**Principle Area of Disagreement Statement**  
**North Yorkshire County Council and Richmondshire District Council**

**Deadline 5 Submission:**

Drawing Title: De-trunking Plan Regulation 5(2)(o) Sheet 1 of 1

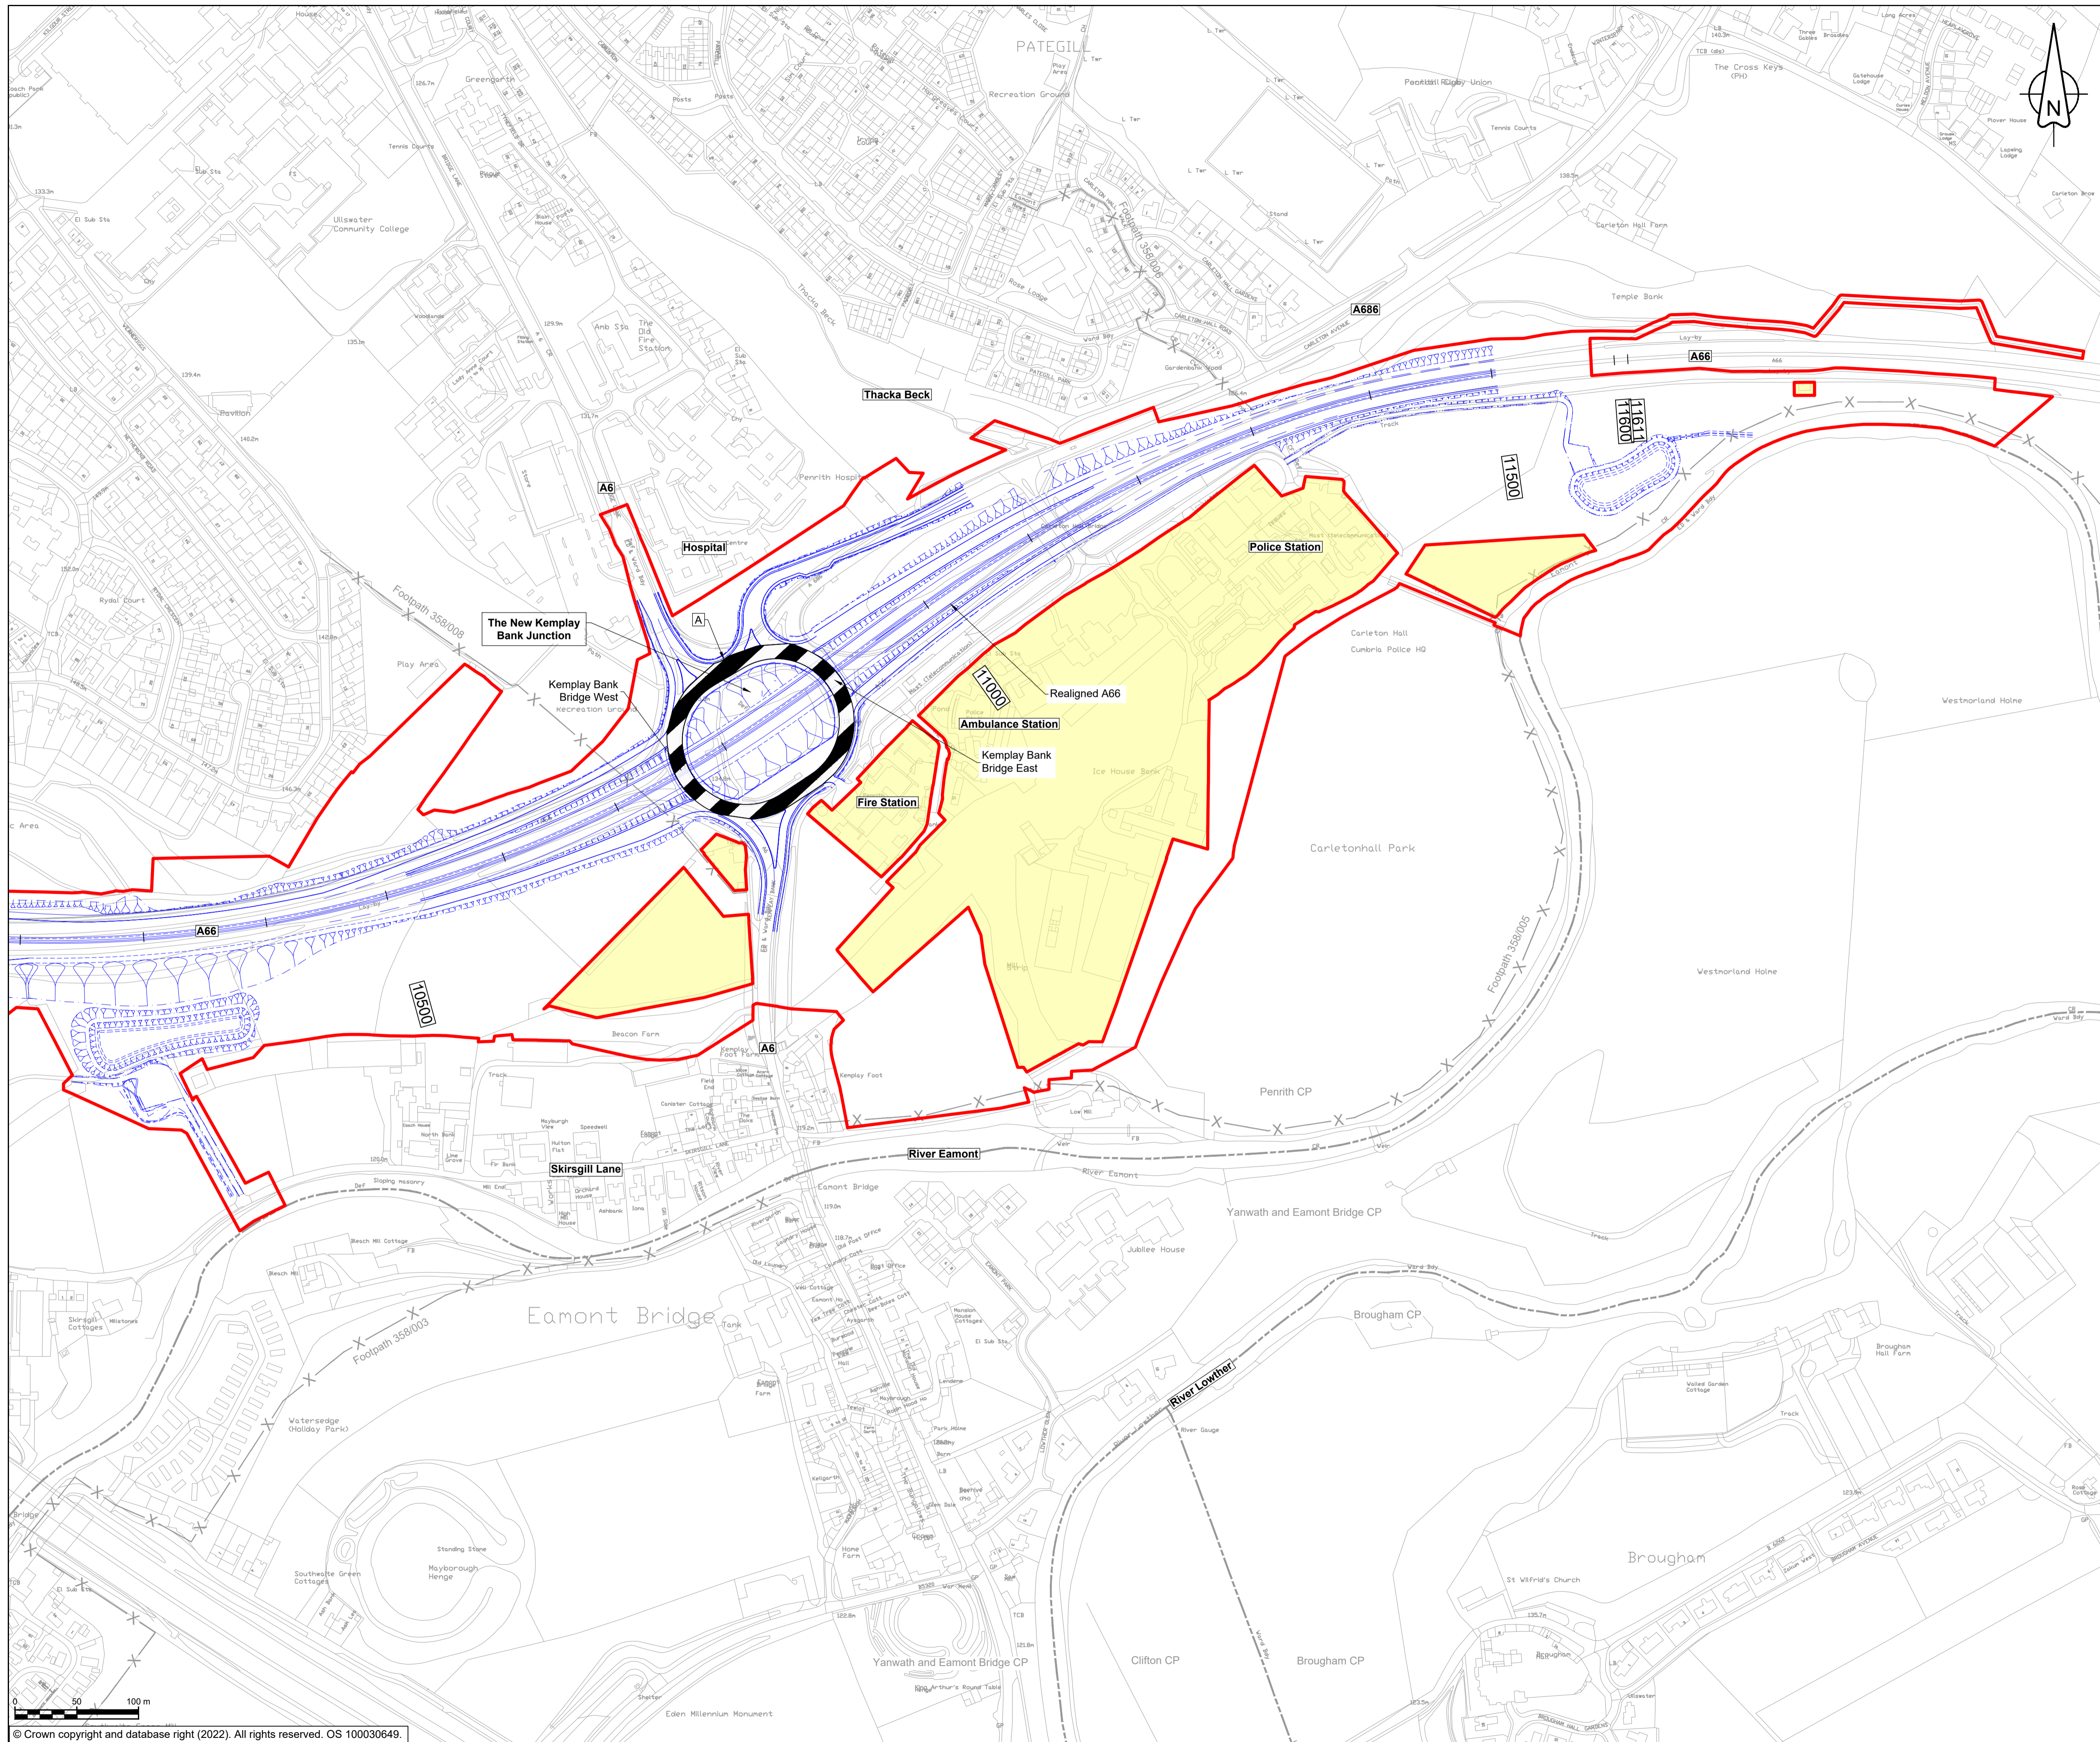
Highway Design	A clear and detailed strategy is required for the section of the A66 that is to be “de-trunked”. It is assumed that any “de-trunked” sections of the existing A66 do not include a maintenance backlog, and that commuted sums will be provided by National Highways to support future up keep. We also consider that transferred sections of the route should be subject to enhancements where these are considered to best reflect their new role, for example improved junction arrangements or the introduction of improved facilities for non-motorised users.	The continued development a clear de-trunking strategy is required.  Continued discussion as to commuted sums and enhancements is required	Likely
Ecology	The ES identifies that a residual adverse effect remains in relation to	Continued work with the applicant and development of the dEMP	Likely
